Application Ref:		3/2026/0474		 Ribble Valley Borough Council www.ribblevalley.gov.uk
Date Inspected:	N/A	Site Notice:	N/A	
Officer:	AR			
DELEGATED ITEM FILE REPORT:				APPROVAL

Development Description:	Lawful Development Certificate for proposed detached garage/car port.
Site Address/Location:	1 Cockleach Cottages Chipping Road Longridge PR3 2NB

PLANNING
Drawing Title: Proposed Plans and Elevations
Drawing No: 26053-MCK-V1-ZZ-DR-A-15001-3P01
Date: Jun 2026
Scale: 1:200
Checked: PS
Drawn: MS

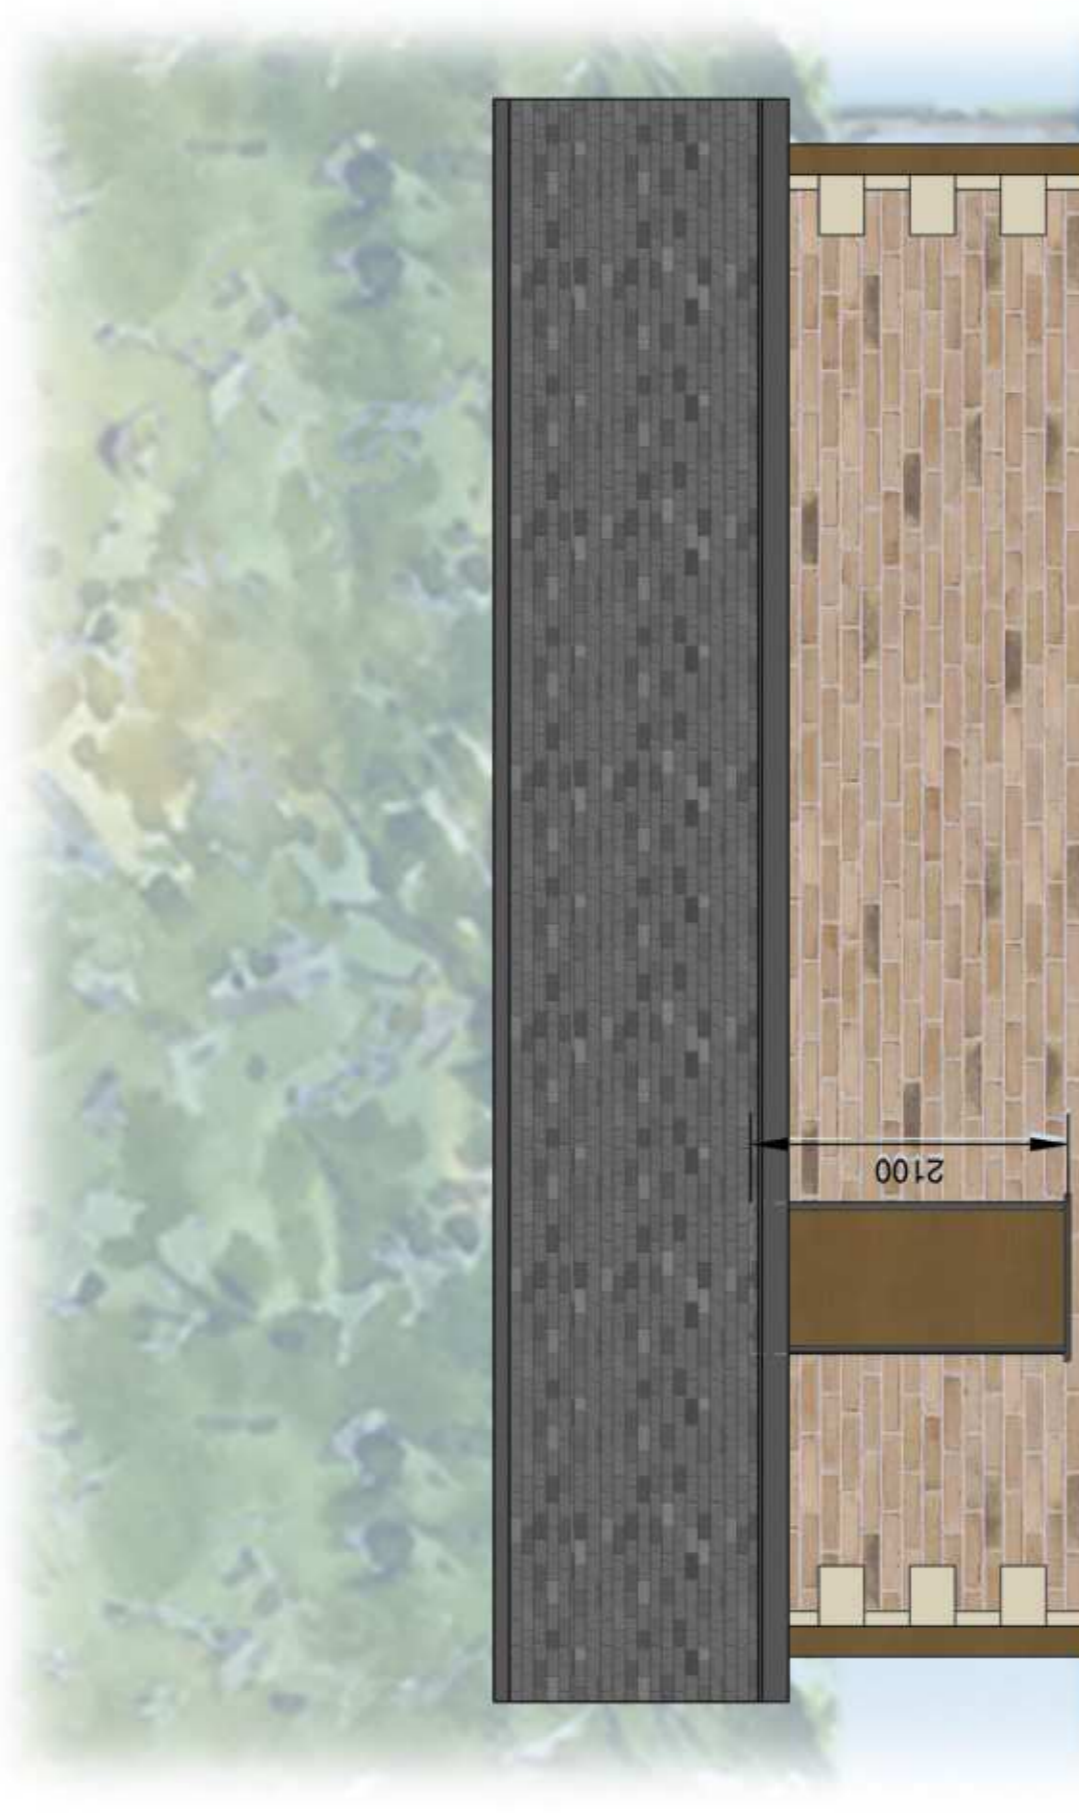
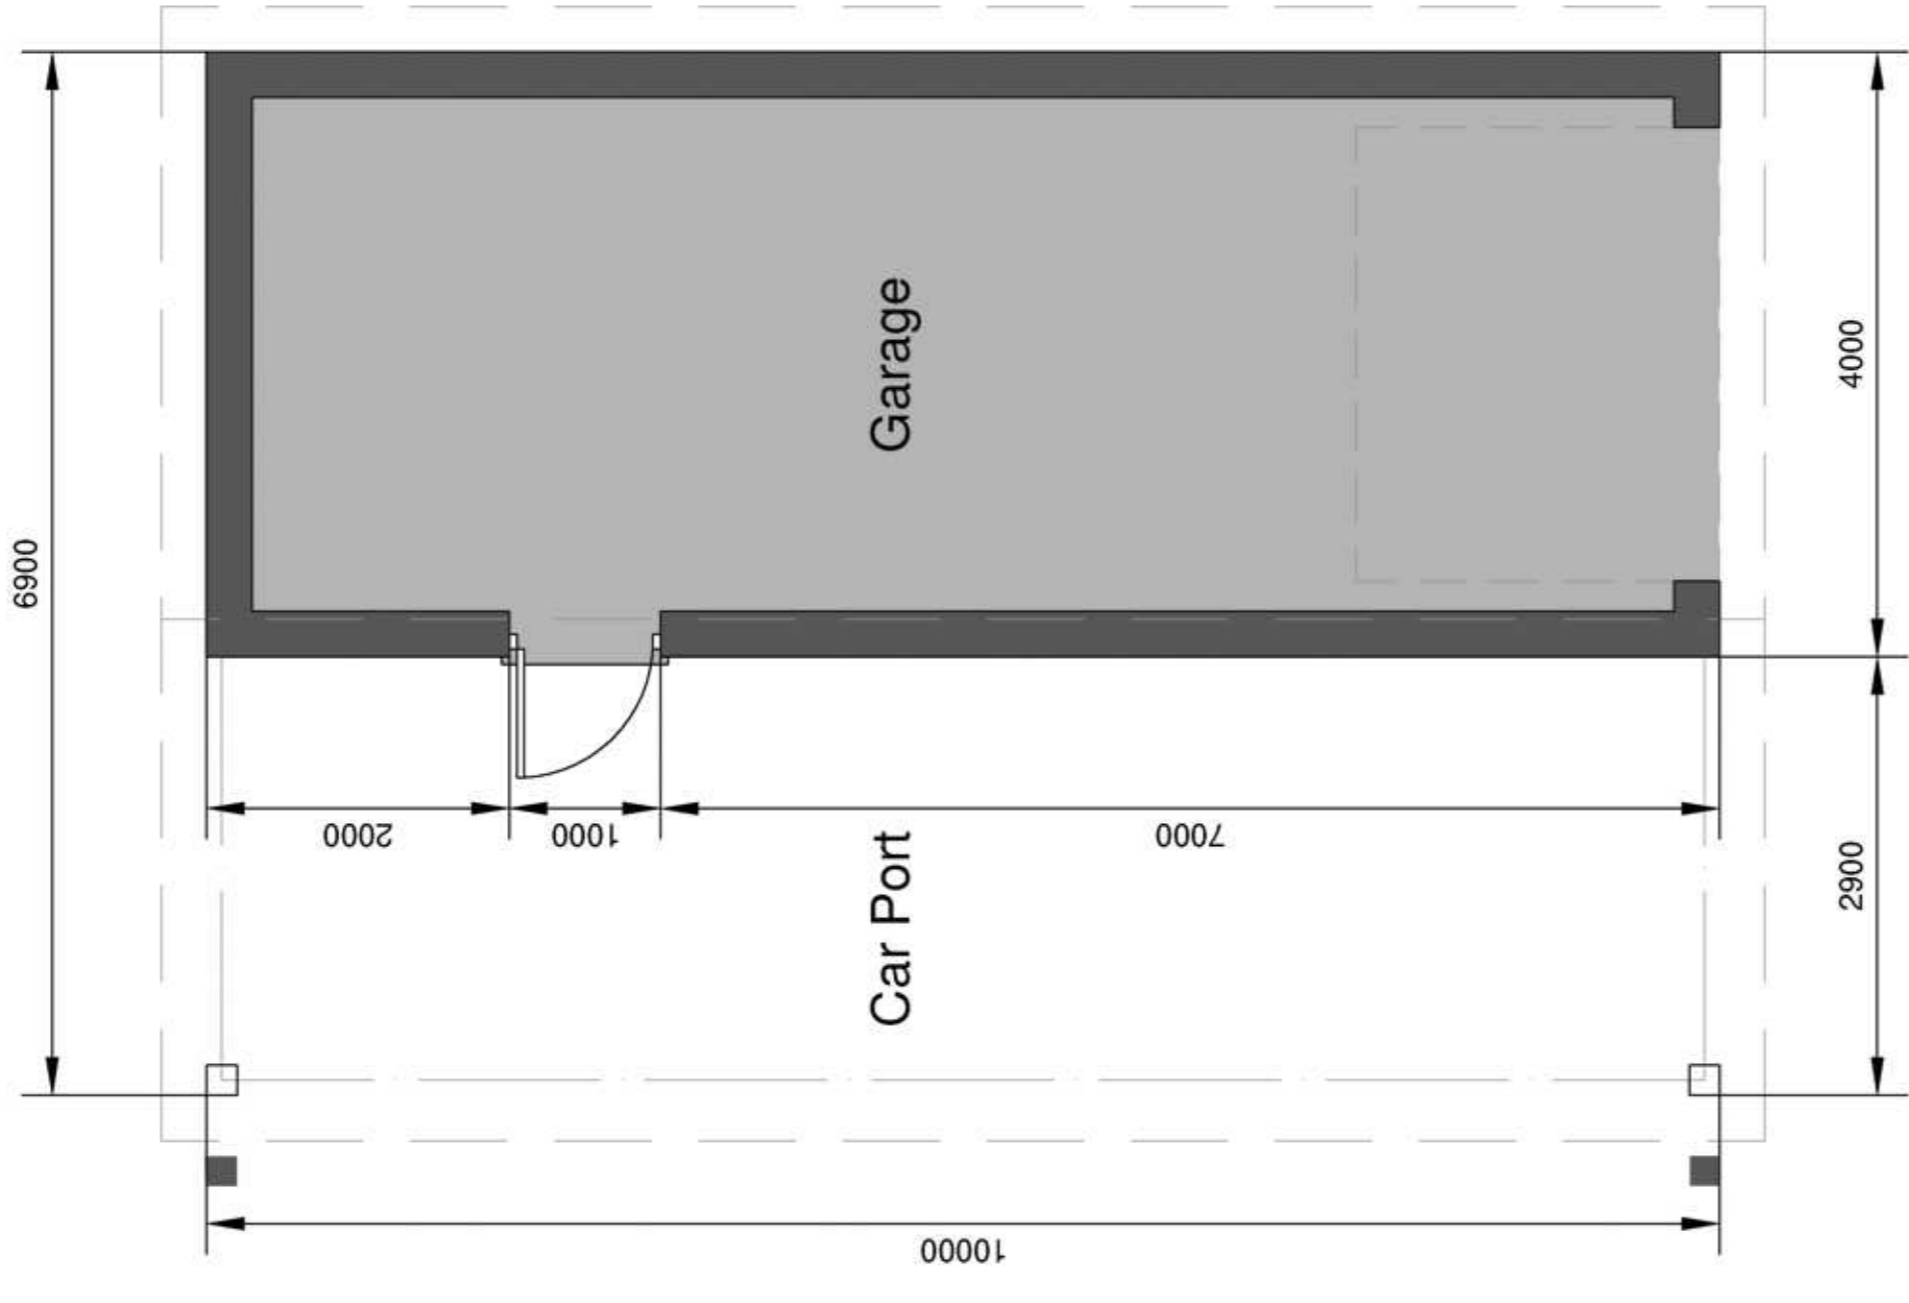
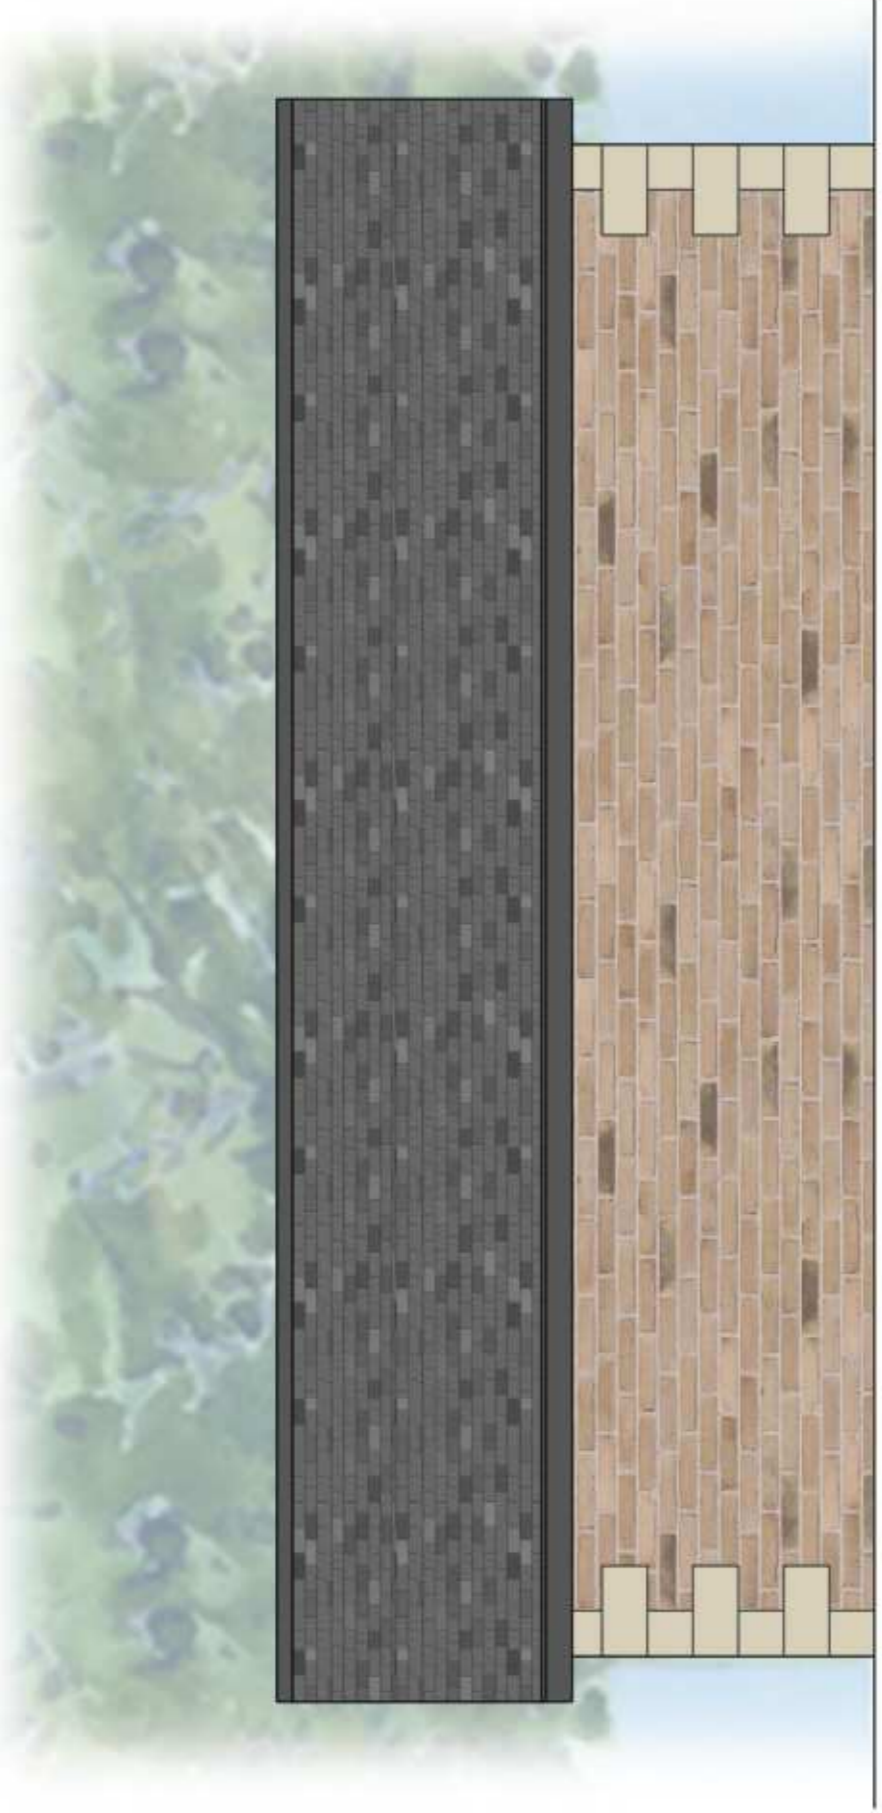
The proposed outbuilding would measure 6.9m in width by 10m in length and would feature a pitched roof with a height of 2m to the eaves and 3.95m to the ridge. The garage would have a width of 4m, and the carport would have a width of 2.9m. To the garage's front elevation, a garage door would be installed, whilst to the garage's north-east side elevation, a single door would be installed to allow access out to the carport. The proposed outbuilding would be located 4m from the rear elevation of the dwelling house and 2.1m from the curtilage boundary.

The proposal would not have more than a single storey.

The proposed building would not be within 2 metres of the curtilage boundary and would feature a dual-pitched roof measuring 3.95m in total height.

The eaves height of the building would not exceed 2.5m.

Drawing Title: **Proposed Site Plan**

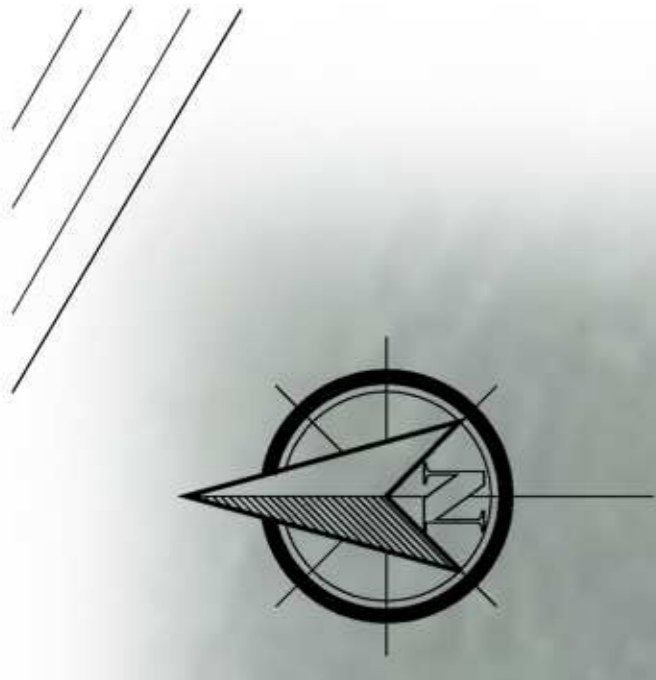
Any part of the proposed outbuilding would not be situated on land forward of a wall forming the principle elevation of the original dwellinghouse.
